164-166 DARTMOUTH STREET

LAND USE - ZONING REPORT

ADDRESS: 164 Dartmouth St DATE: 8/27/96
REASON FOR PERMIT: erect AN Above ground pool (permit After The fact)
BUILDING OWNER: Cristin French C-B-L: 117-D-22
PERMIT APPLICANT: owner
APPROVED: with conditions DENIED: _____
#9

164 Dartmouth
Portland 04103
15' x 4' pool

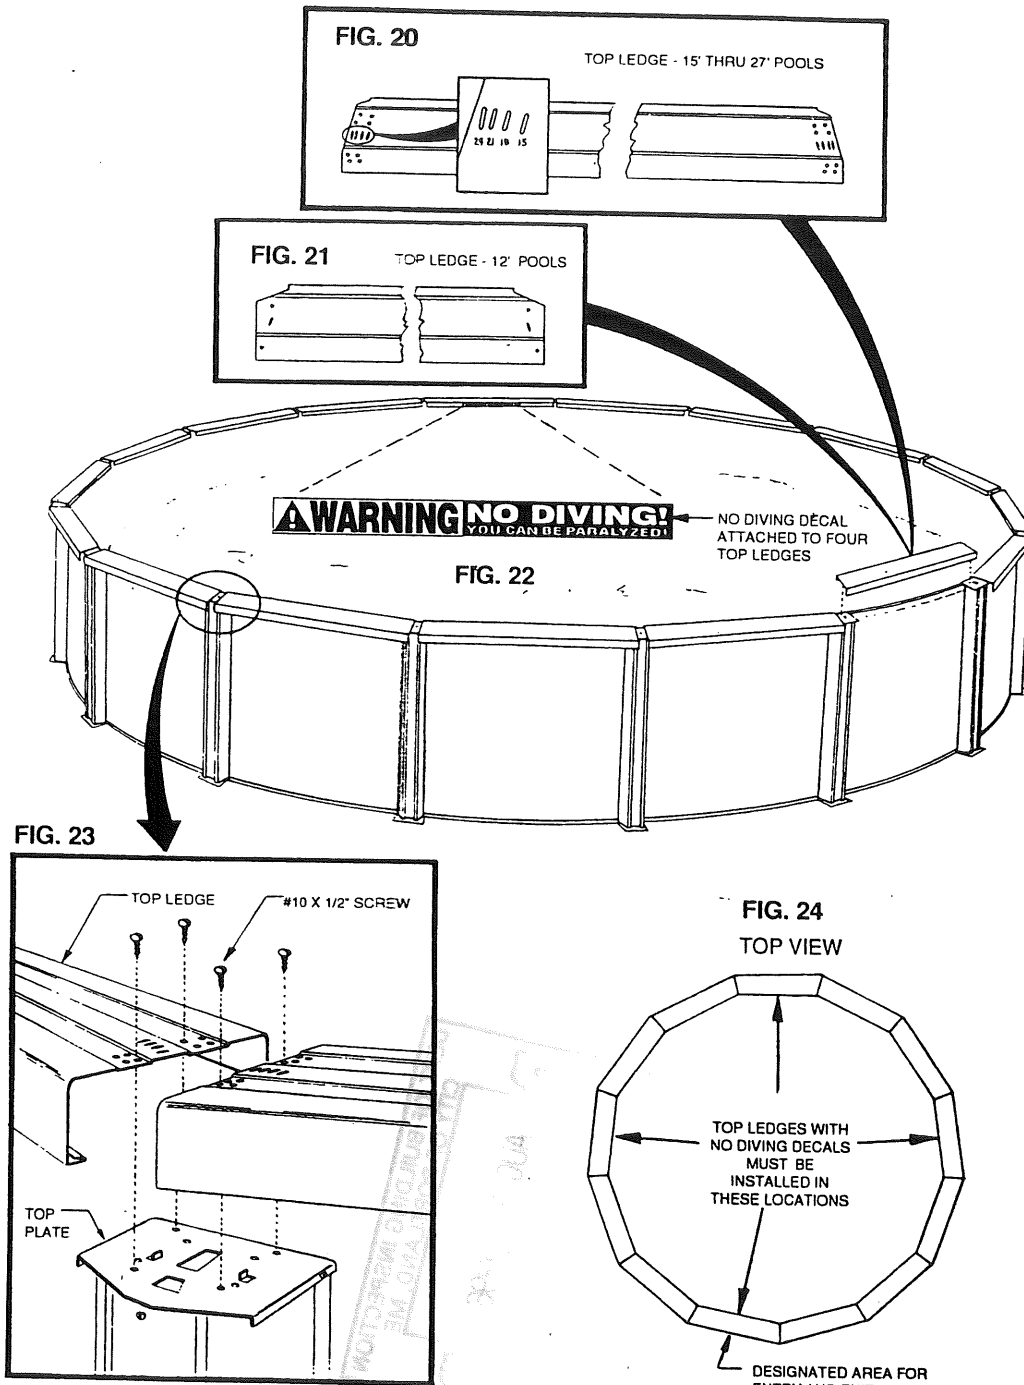
7. Separate permits shall be required for any signage.
8. Separate permits shall be required for future decks and/or garage.
9. Other requirements of condition The pool shall be located no closer than

ten (10) feet from the principal structure, nor closer than
ten (10) feet from the side or rear lot lines. If you can not
move the pool to meet these regulations, this approval
becomes invalid and the pool shall be removed.
